From: Matthew Chadwick
Sent: 01 June 2020 09:34
To: DC Support
Subject: FW: Duns Tew solar farm access

Following review of the revised drawings submitted with the email below (22 May), I can confirm that the OCC Highways objection is withdrawn.

We have reviewed the access against the requirements of the Design Manual for Roads and Bridges (CD123). With regard to the exit from Oxford Road (A4260), a permanent access would require an auxiliary lane rather than a diverge taper as the AADT is greater than 7000. However, in this situation which is temporary in nature, has relatively few movements and will have advance warning signs, OCC will accept a diverge taper as shown on your drawing Appendix 6.2.

1:1000@A1	Appendix 6.2	
-----------	--------------	--

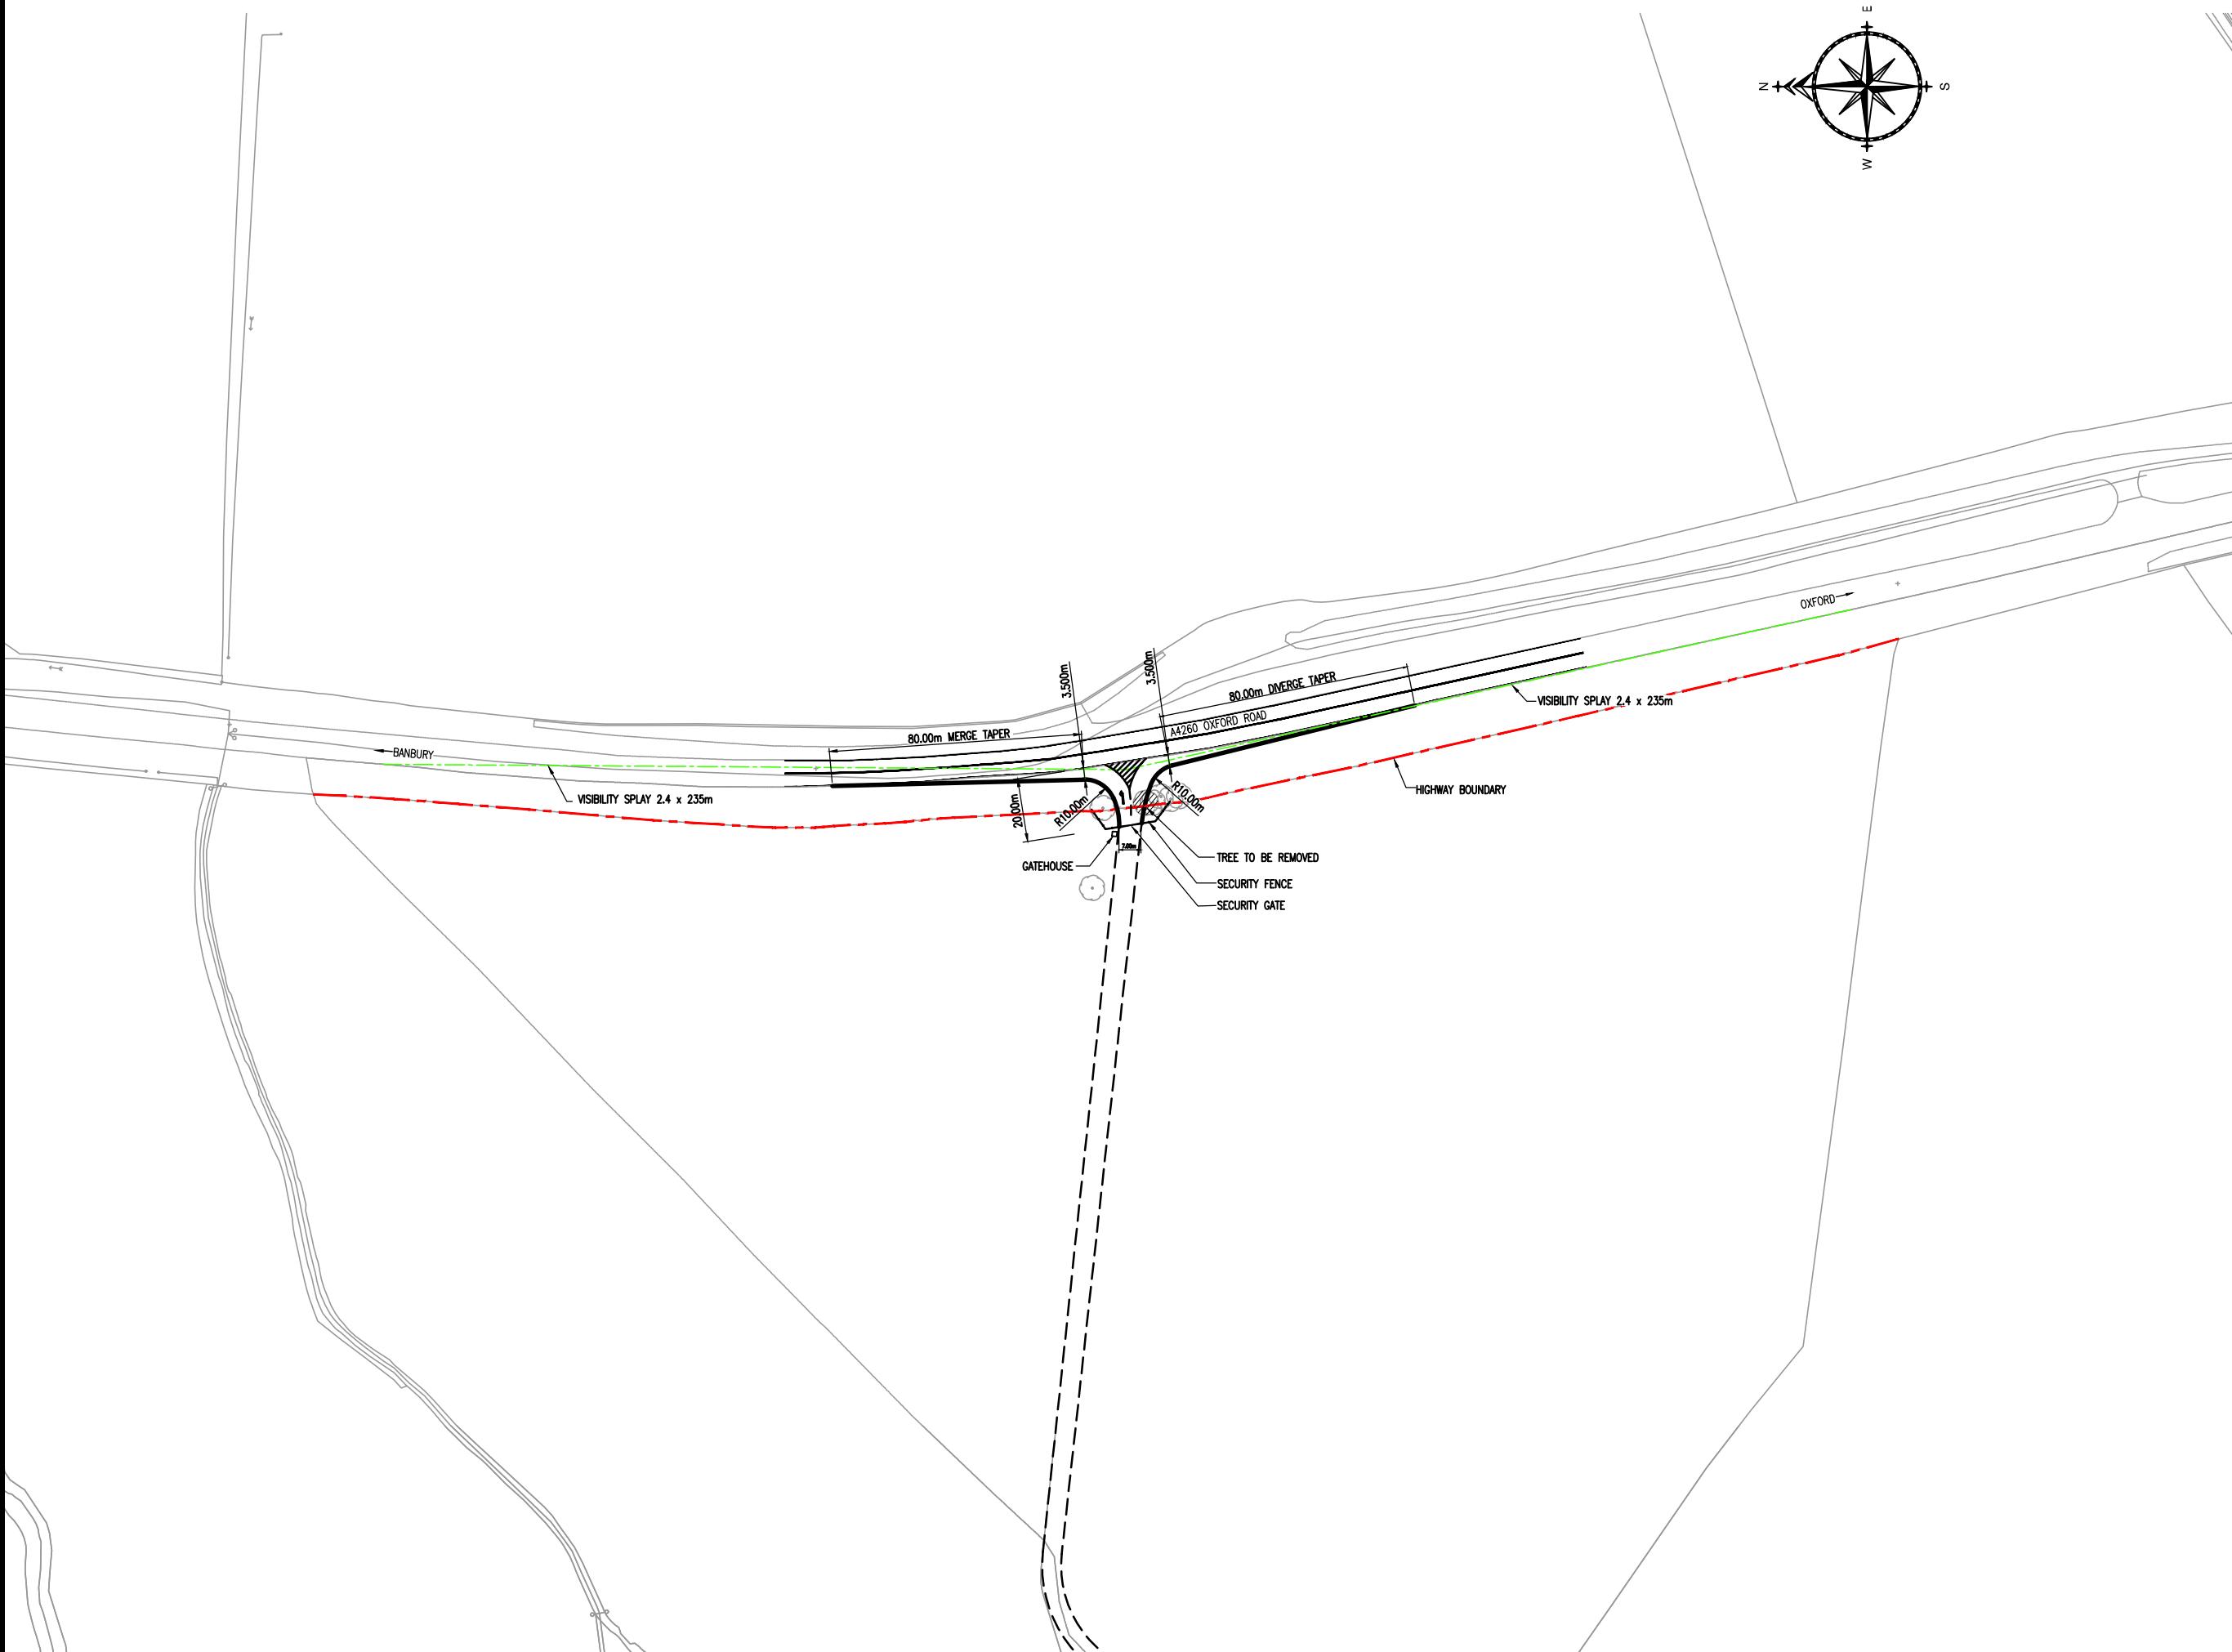
CD123 states that merging tapers may only be used on dual carriageways, and so the inclusion of a full merging taper is not acceptable in this location. Instead, the exit on to the A4260 should

have a generous corner radius and possibly a short length of “taper” to ease the HGV merging manoeuvre that will be on an upslope.

I will be happy to remove my objection if you are able to make this adjustment to the merging taper.

For clarity, the *merge* taper has been removed, not the *diverge* as stated below.

Please find attached the revised temporary construction access which deals with the issue of the diverge lane which has been removed.

We have increased the kerb radius on the exit to 15m and as you can see from the swept path analysis the delivery vehicle can turn left on to the A4260 without crossing the double white lines.
